CITY OF ALBUQUERQUE

PLANNING DEPARTMENT – Development Review Services

May 30, 2014

RE: **Valle Prado Units 1&2 - Tracts 9 and OS-3**
Drainage Report for Valle Prado at the Trails Units 3A
Engineer's Stamp Date 5-2-2014 (File: C09D011)

POND E
SCALE: 1" = 50'

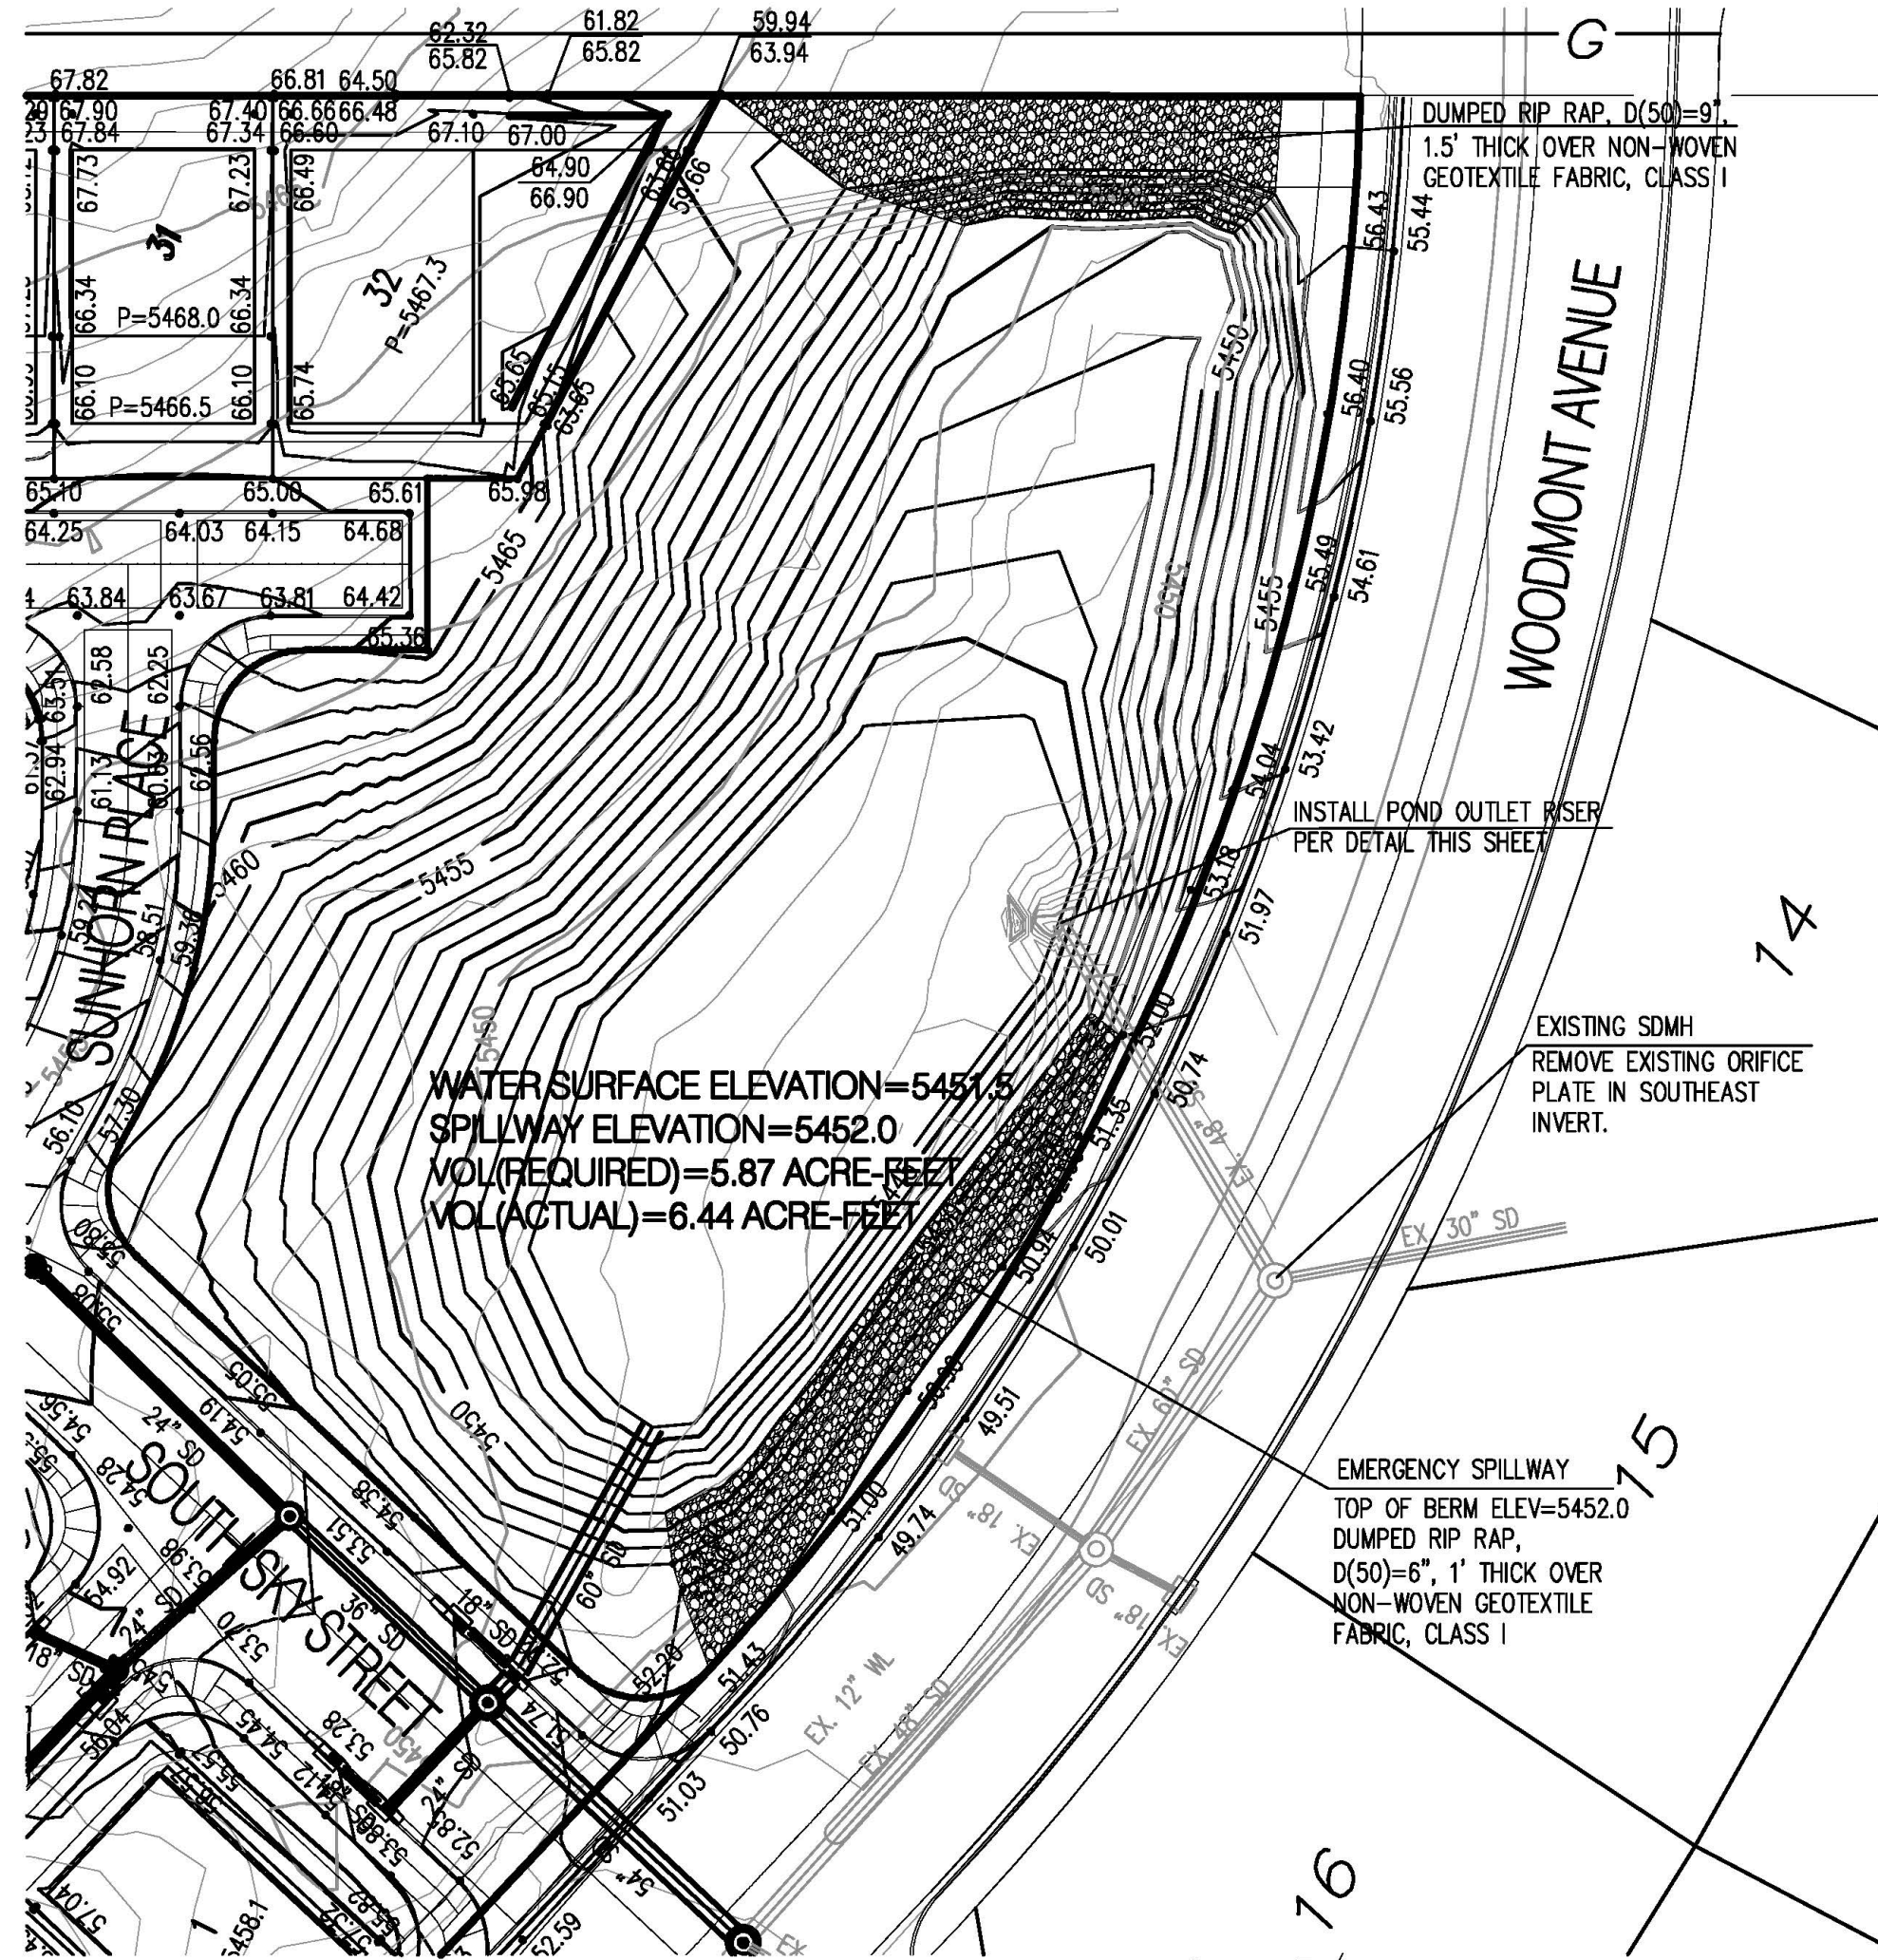
9. Pond E is noted as a future pond. However, the DMP shows the south and southwest portion of Basin E5 draining to Pond E, rather than a storm drain. Therefore Pond E needs to be sized correctly to contain flows delineated in the DMP. Furthermore, Pond E could be used to pick up the “first flush” required by the drainage ordinance. Pond calculations need to be provided.

19. Some or all of Pond E should be constructed with this project and shown on the grading plan. Pond volume, WSEL, and emergency overflow should be shown as well. Show grade lines along Sunhorn Road adjacent to the pond.

SANDMARK ROAD SEDIMENTATION POND
SCALE: 1" = 50'

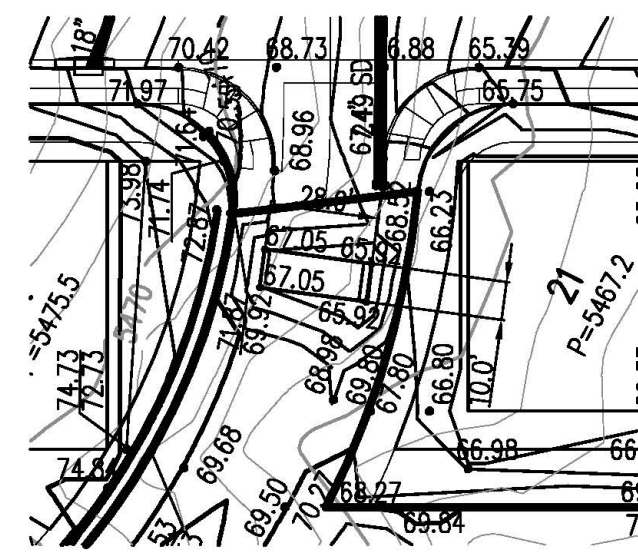
10. The Temporary Sedimentation Ponds located in Future Basins 1,2, 3, and 4 need to be sized to pick up the correct volumes. They seem to be temporary ponds that pick up offsite flows rather than sedimentation ponds.

20. Hooded Sage Street should not extend into Pond easement, nor can a street be supported by a retaining wall.
21. The Temporary Sedimentation Ponds located in Future Basins 1,2, 3, and 4 need to be shown on Grading Plan with the pond volume, WSEL, and emergency overflow indicated.

22. The berms near the Temporary Ponds need to be detailed and dimensioned.
23. Show street slopes. Some street slopes seem to be high.
24. Show contours in well site and beyond northeast boundary, inside of gas line easement.

PLATE 1

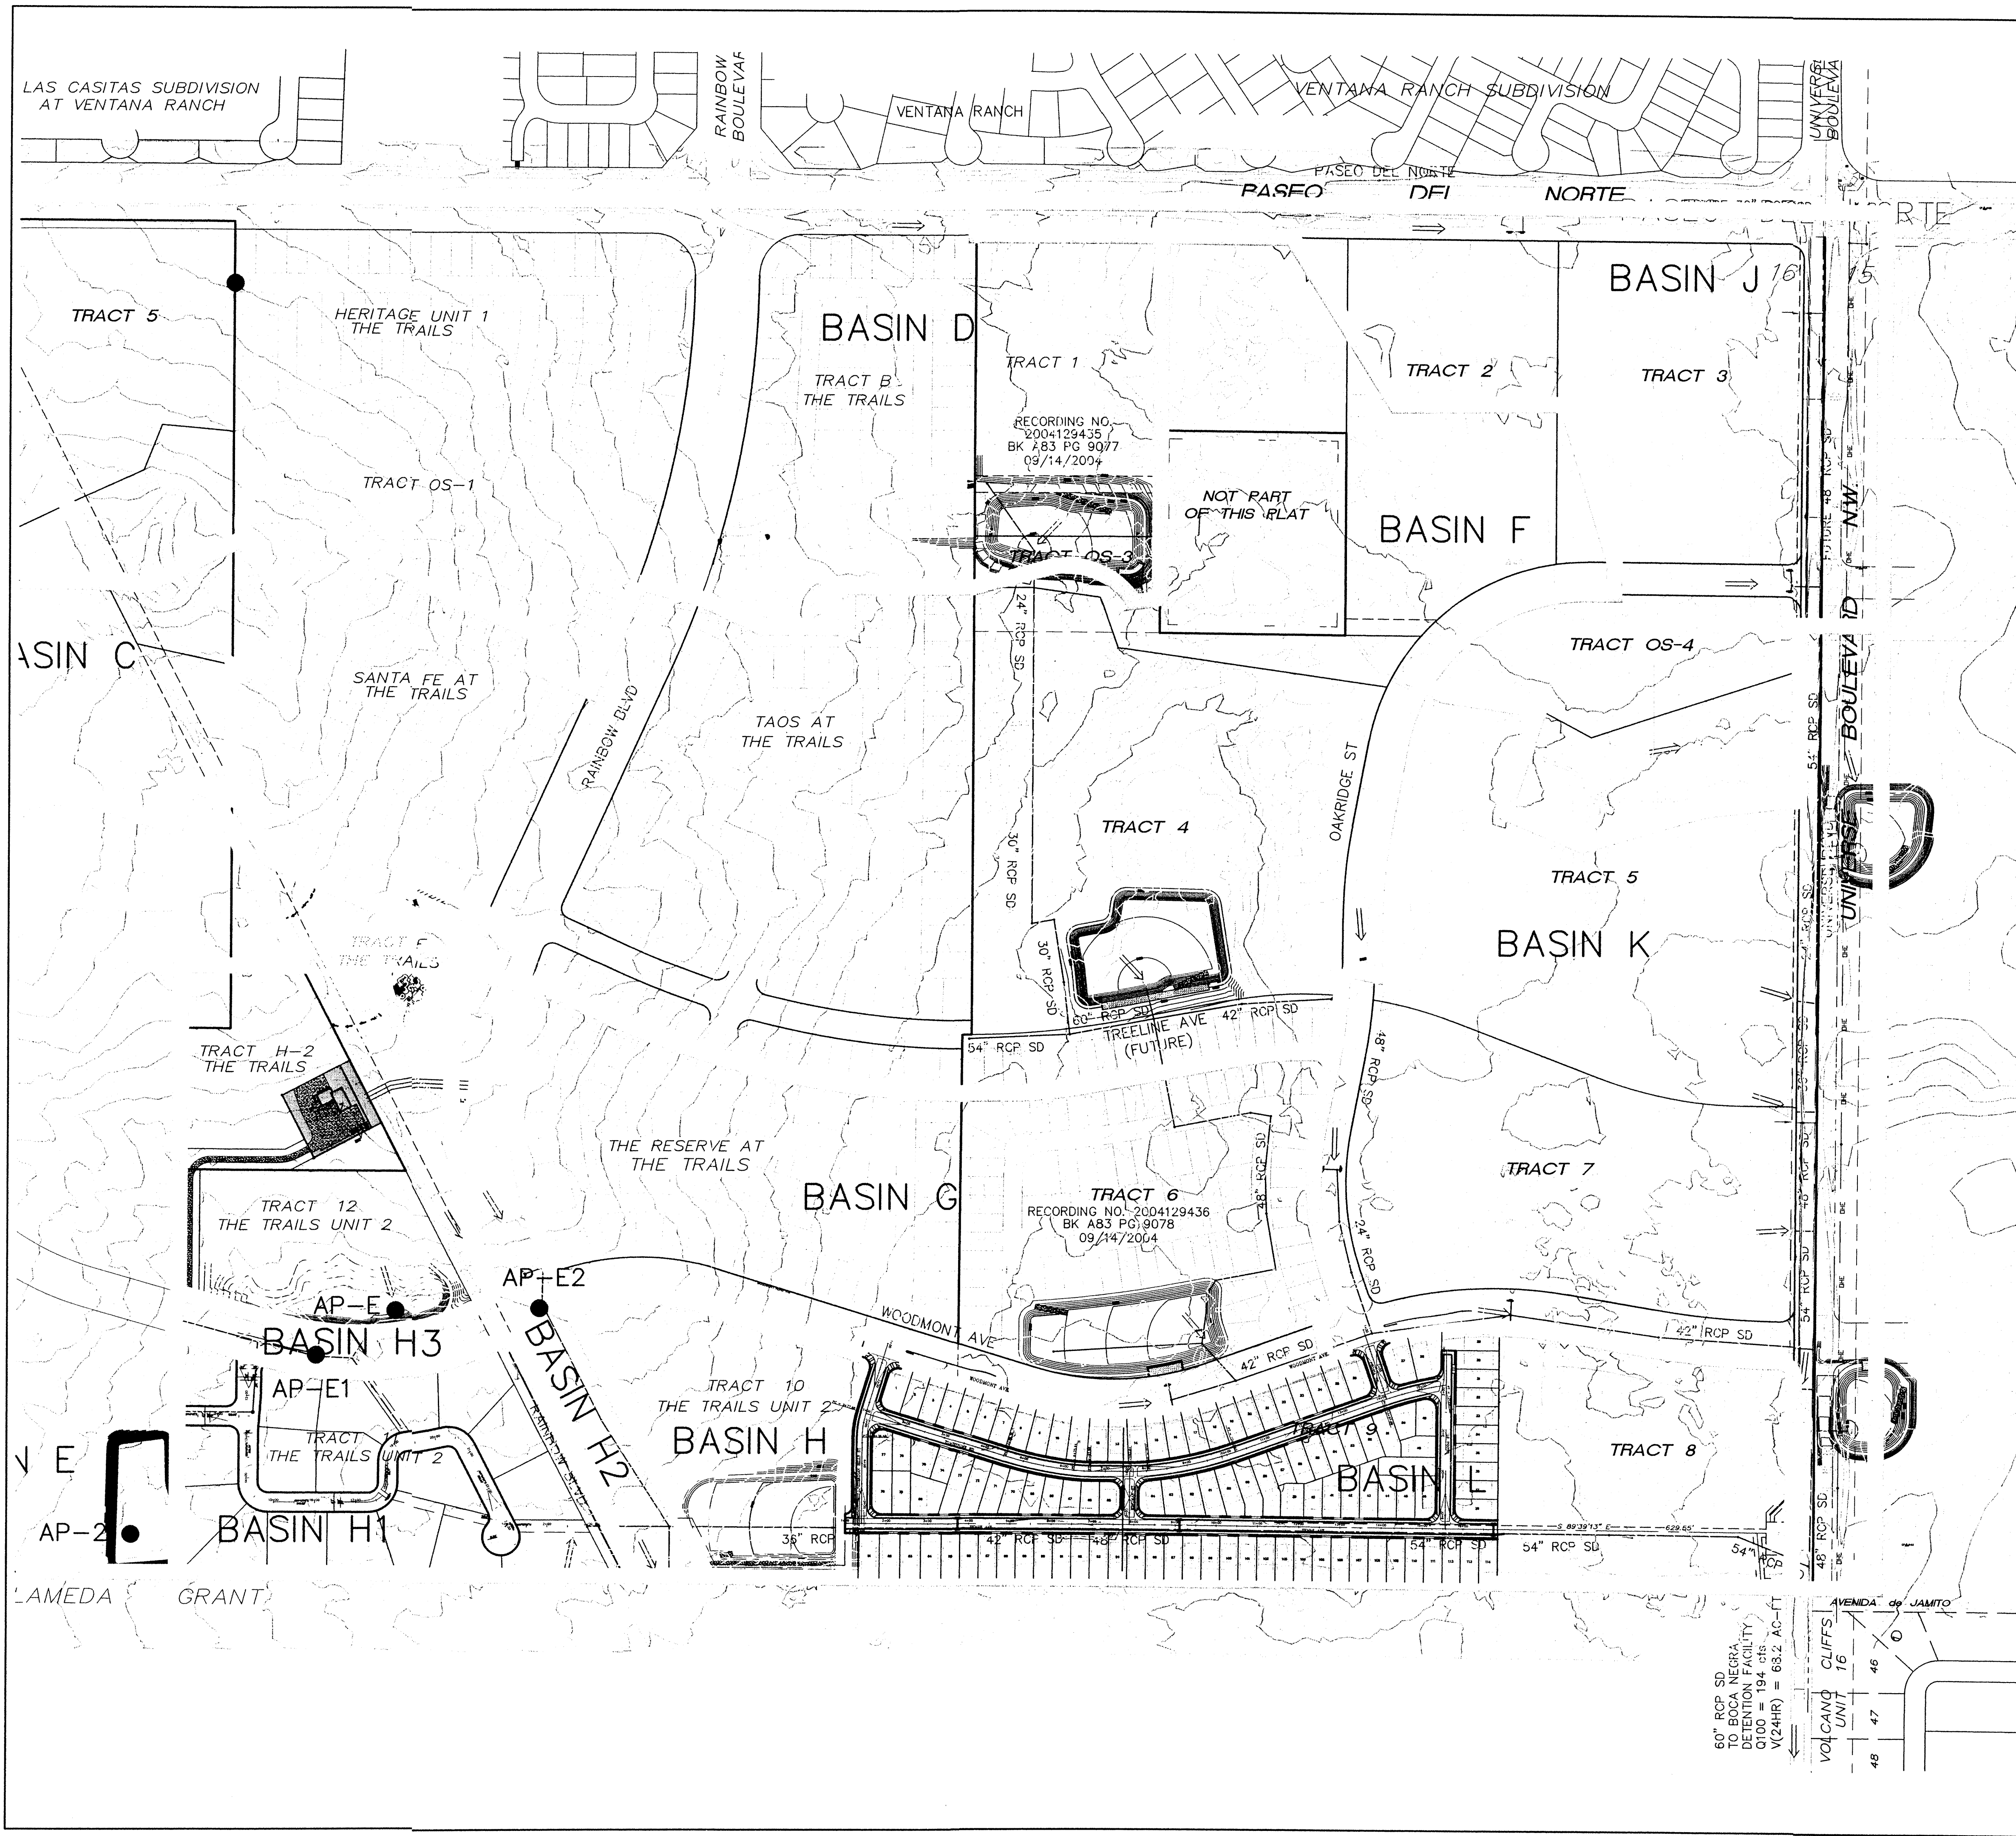
2. There is an inconsistency in the AHYMO output file in the DMP verses the Table shown on Plate 2 of the DMP that needs to be resolved. The AHYMO indicates AP-E as 15.5 cfs, whereas the table indicates 22.3 cfs.
